CONSULTEE RESPONSE (Council's Arboriculturist)

Reference: BN/21/22/PL

Proposal: Demolition of existing care home and construction of 5 no. dwellings and garaging, with landscaping and associated works. This application affects the setting of a listed building and is in CIL Zone 2 and is CIL Liable as new dwellings

Location: The Hollies, 84 Barnham Road, Eastergate, PO22 0ES

Appendix 9: Tree Protection Plan

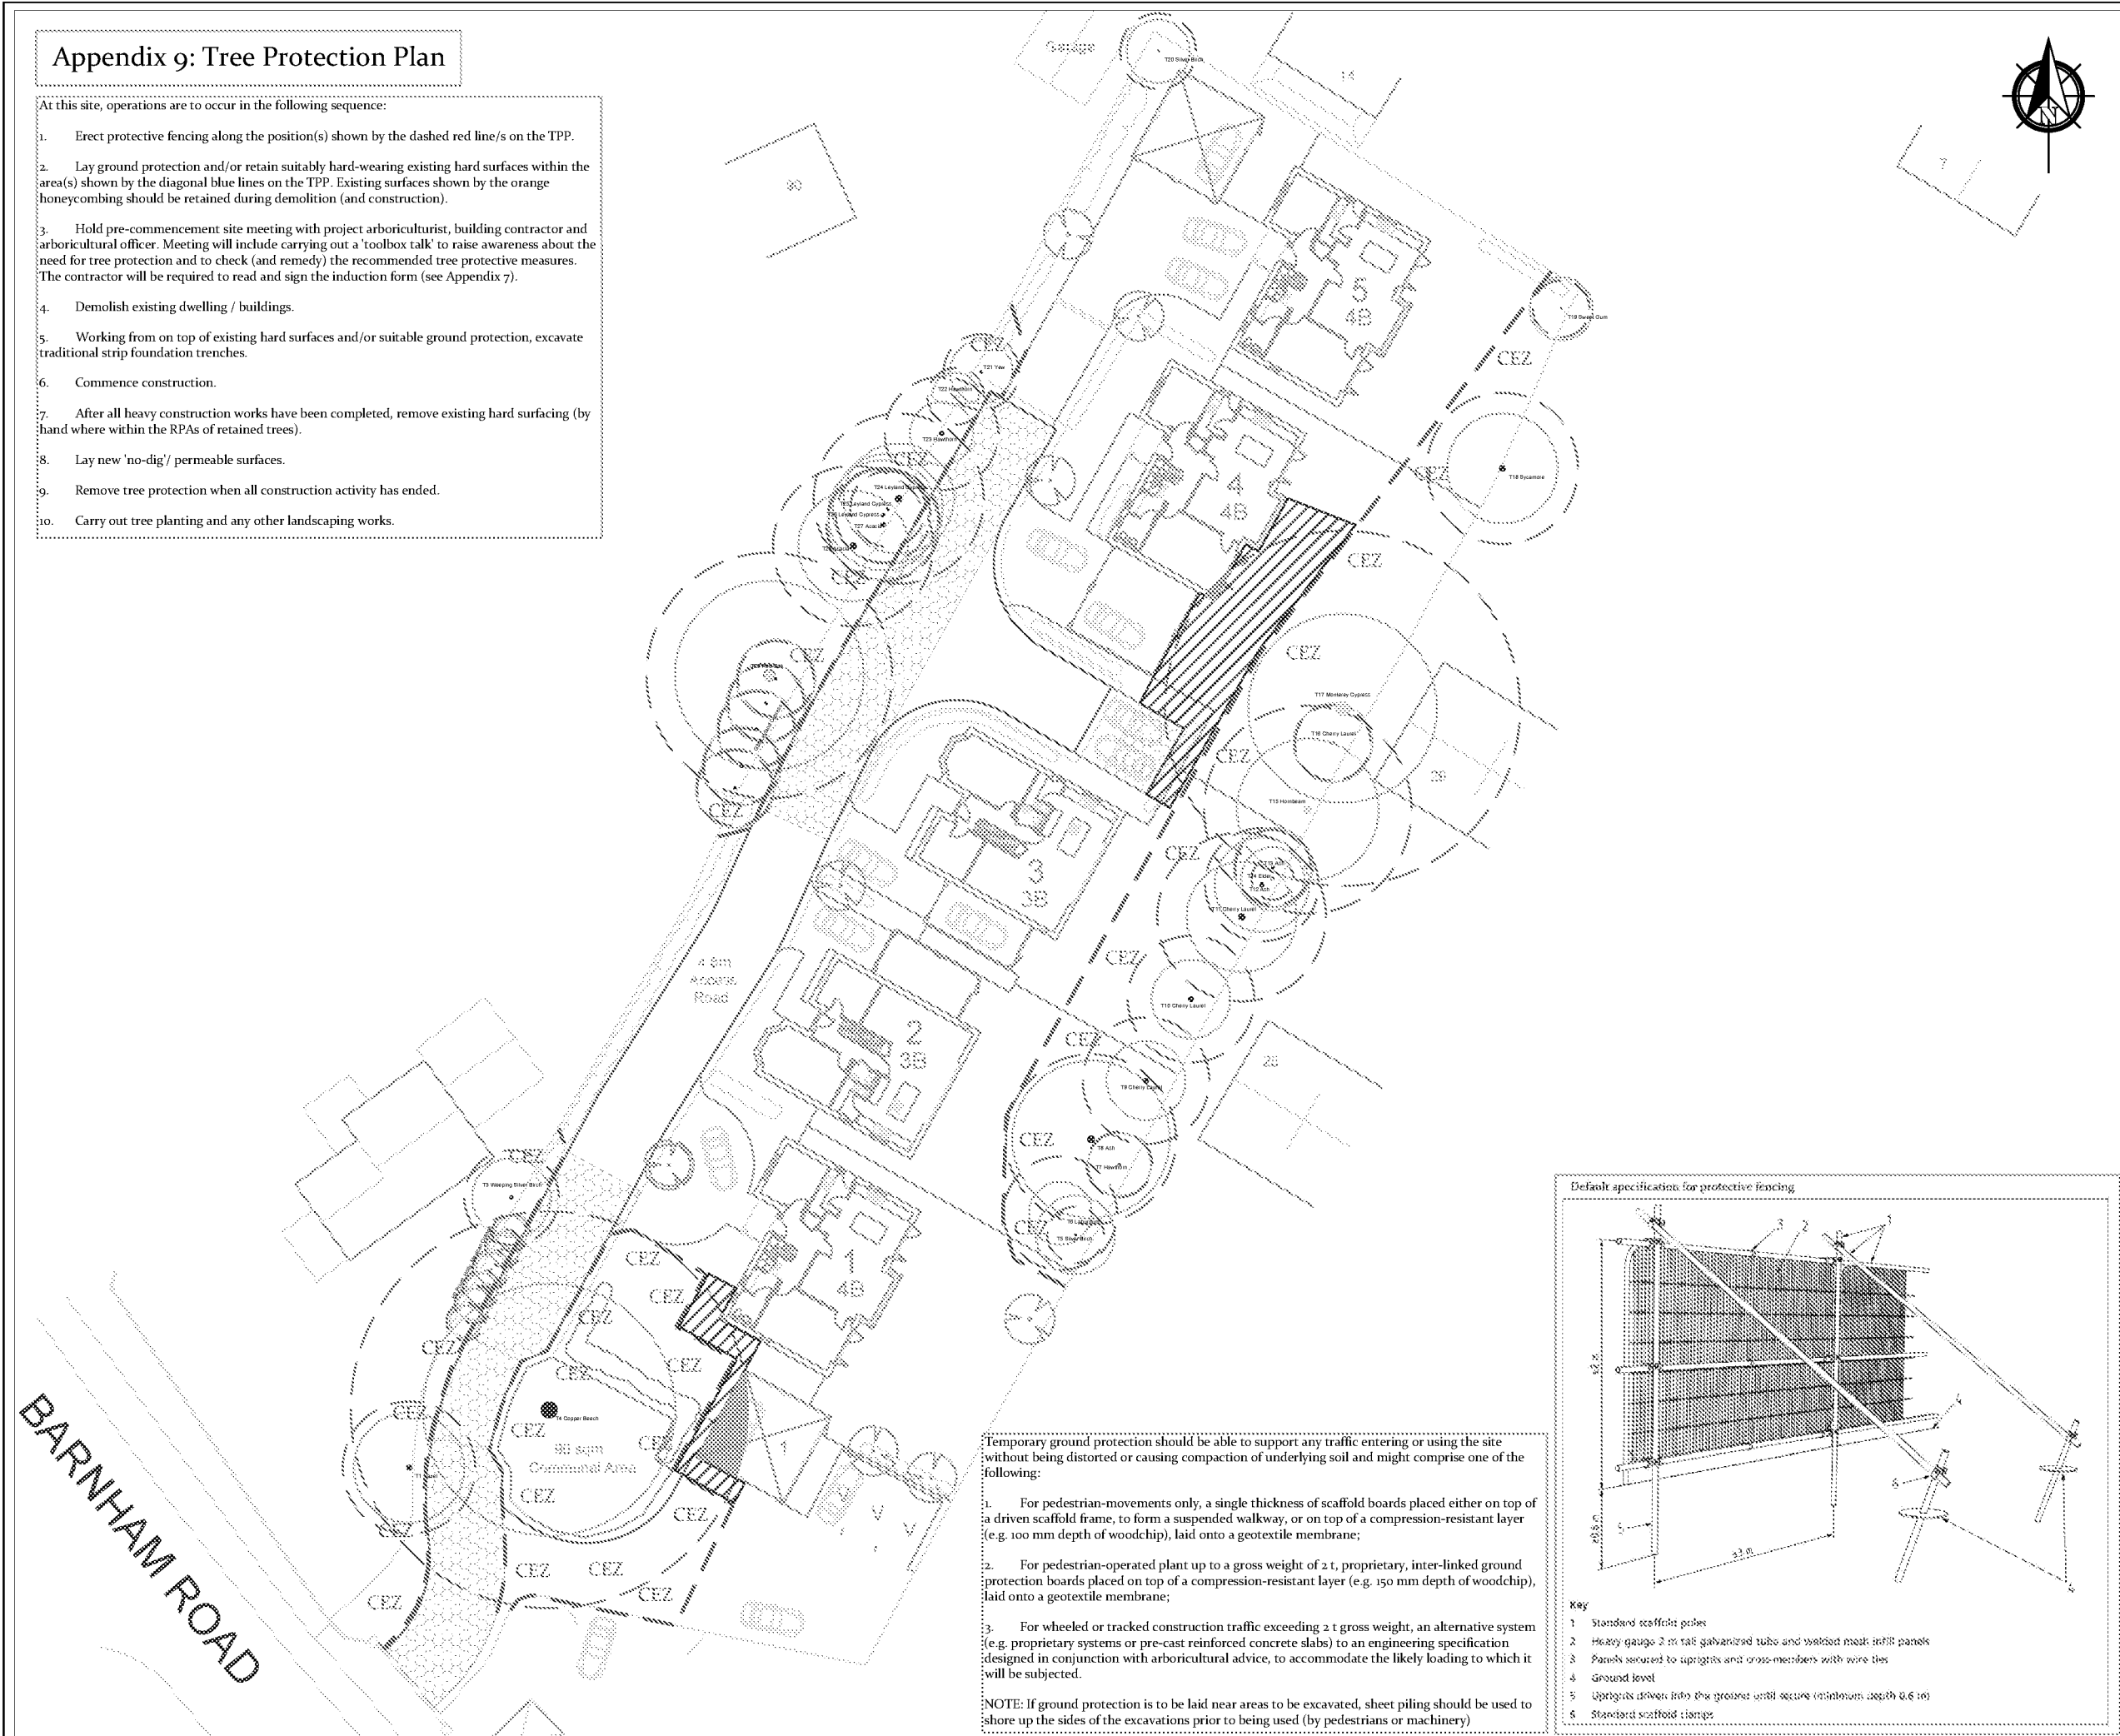
Approval of the proposed drainage strategy (heavily reliant on infiltration through carriageway) appears critical to securing a low impact on retained trees - an alternative may demand tree removal/damage.

Foul water and other service-runs in and out of site have not been confirmed or shown in detail, so there remains a risk of root protection incursion at significant depth to satisfy those requirements.

We do not have an approved surface water drainage (and foul water sewer) strategy for the site. This fundamental element of the design ought to be addressed to our satisfaction in association with layout proposals, so that we are not subsequently held hostage to flood mitigation measures which could then impact heavily on retained trees/landscape plans.

Before the site is occupied or any machinery is introduced to the site or demolition work or construction work or alterations to existing ground levels takes place, written confirmation is required from the Arboricultural Expert representing the site owner(s), confirming that all protective fencing and ground protection has been inspected and found to be 'Fit for Purpose' as required under British Standard 5837:2012 and been erected and positioned exactly as shown on the **Tree Protection Plan, dwg no. TH/A3/3023/PP**.

If there is deemed to be a need for any Utility Service Route connections to bisect retained tree Root Protection Areas/Zones, then prior to their installation a Method Statement prepared by an Arboricultural Expert must be submitted that stipulates how this can be achieved without adverse impact on tree roots. Written approval and confirmation of acceptance of this Methodology must be issued before any works are commenced out on site.
